**Our Ref: FN/46/11/
Your Ref:**

Please ask for:
Miss C Burrows
01903 737500 Ext 37459
17th October 2011

**2 storey extension to side of existing dwelling. This application also falls within the South Downs National Park authority
8 Nepcote Findon**

ROOF PLAN  
(1:100)

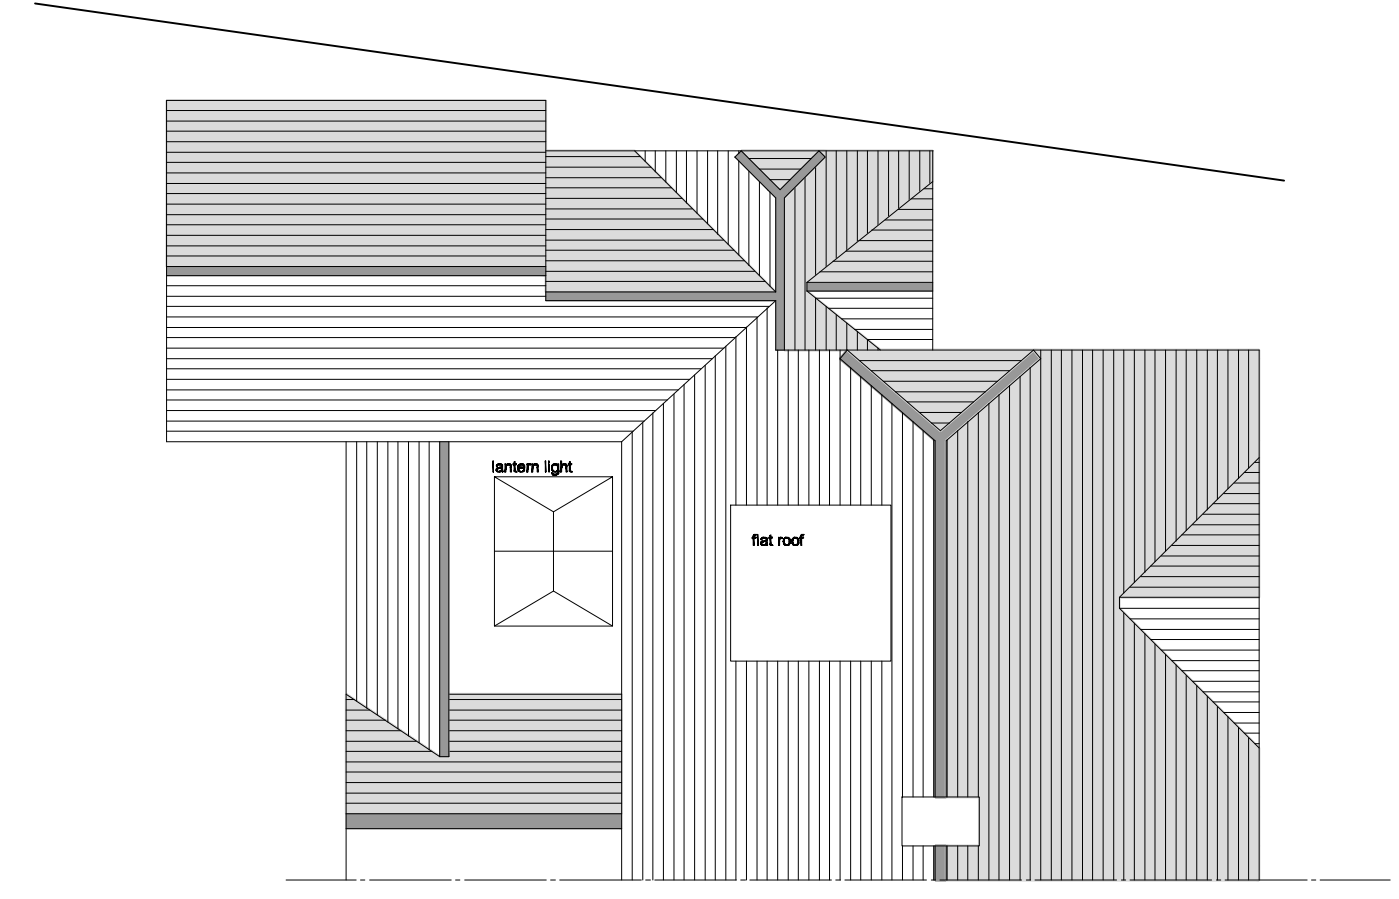
Please confirm in writing whether the Solar Panels are part of the application (as shown on proposed south elevation). If they are part of the application they need to be clearly shown on the block plan, the proposed roof plan and proposed elevations. If they are not part of the application then they need to be removed from the proposed elevations.

I can confirm that the solar panels are to be included in the application.
Having filled in the application form on the Planning Portal, I am confused as to why you require me to fill in an almost identical form in triplicate. I take it you did not receive the Planning Portal application form?
Seeing as there has been some sort of mix up could you please confirm you also received the Design & Access Statement.
Thanks.

Title Proposed Elevations			
Project NEPOOTE (NE)			
Scale 1:50 @ A1	Date Nov, '11	Drawn nb	Rev.
Location 8 Nepoote, Finton, BN14 0SD			
Client Mr M. Adams	Issue BUILDING REGULATIONS APPROVAL		
Drawing no. NE.003	Rev. 001		Rev.

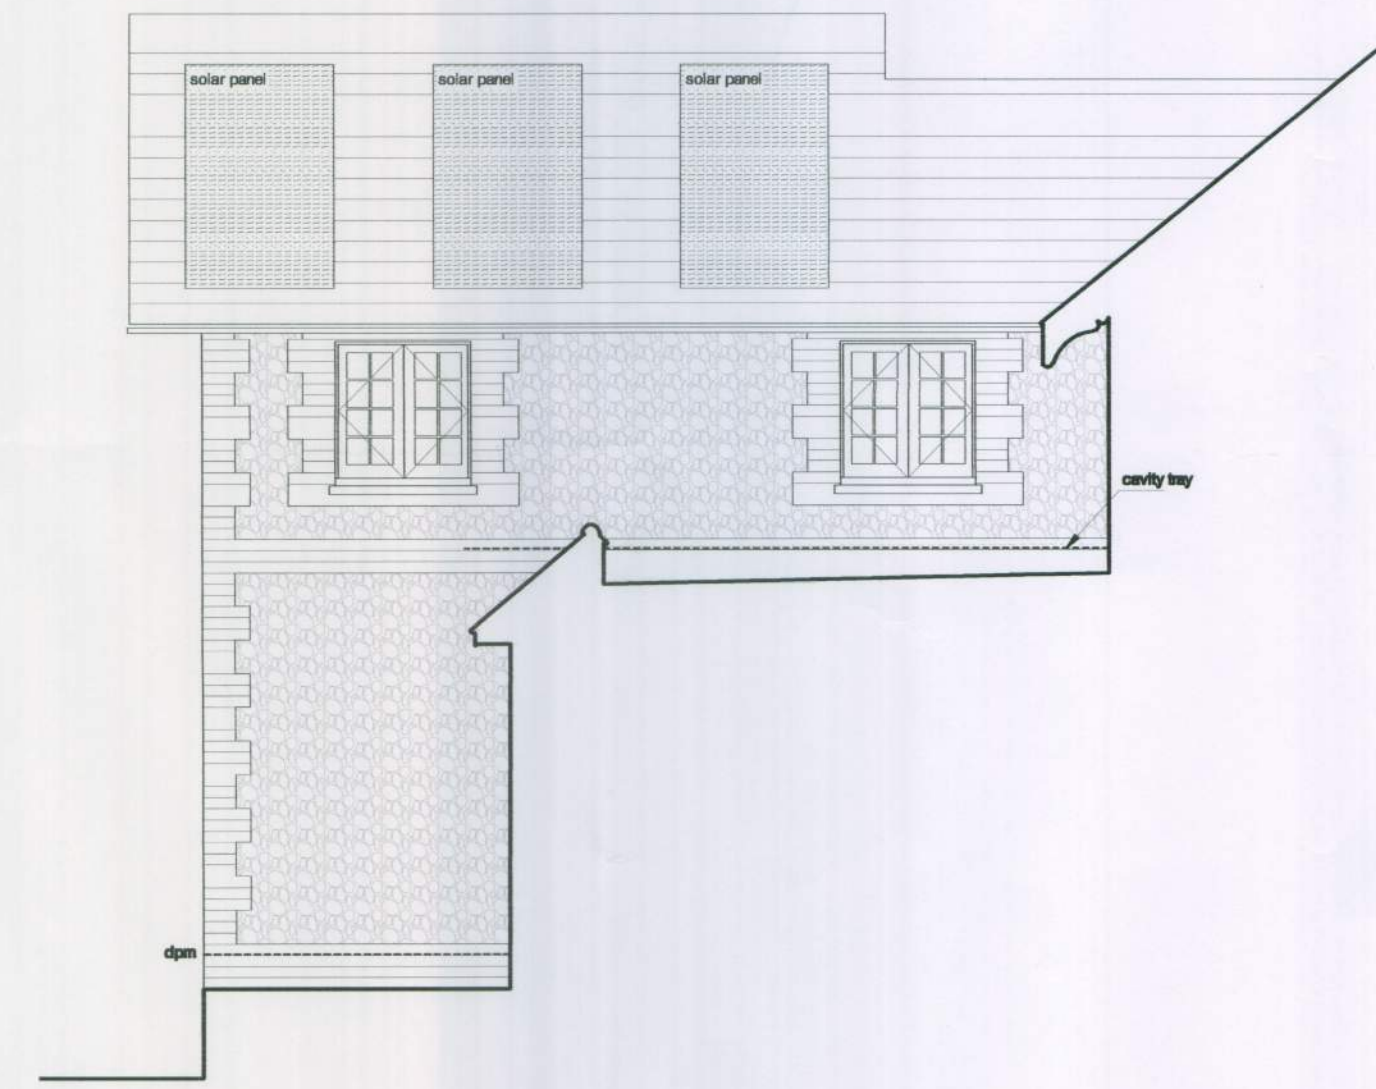
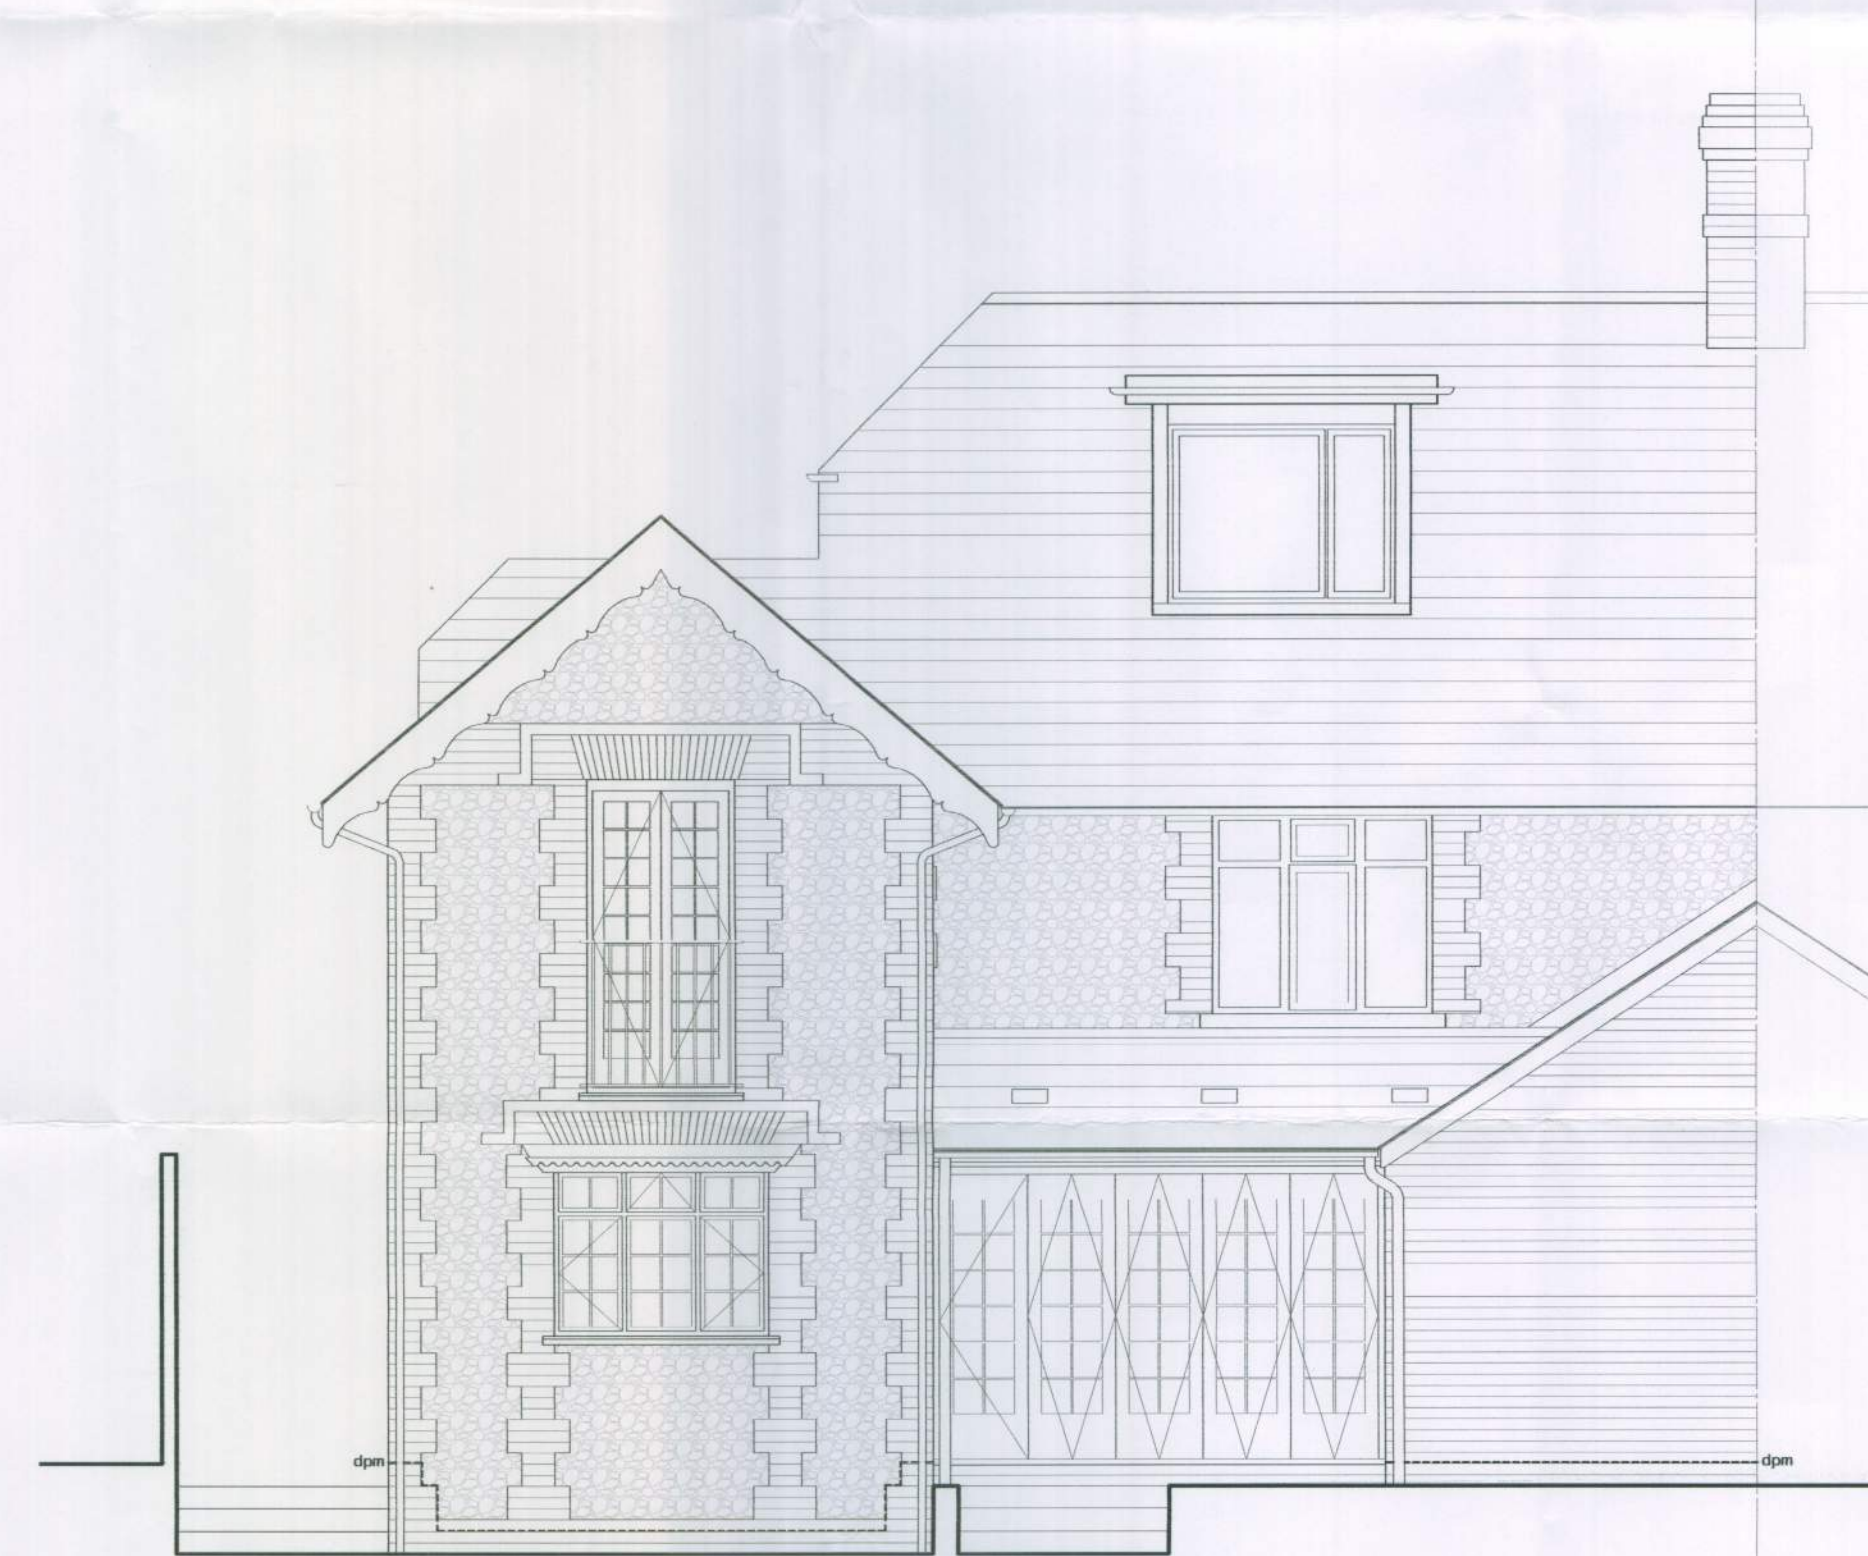
I have had to alter the South Elevation to the above project in order to accomodate a DPC & cavity tray.

Please find attached Building Regs Drg. NE.003 which shows the alterations.
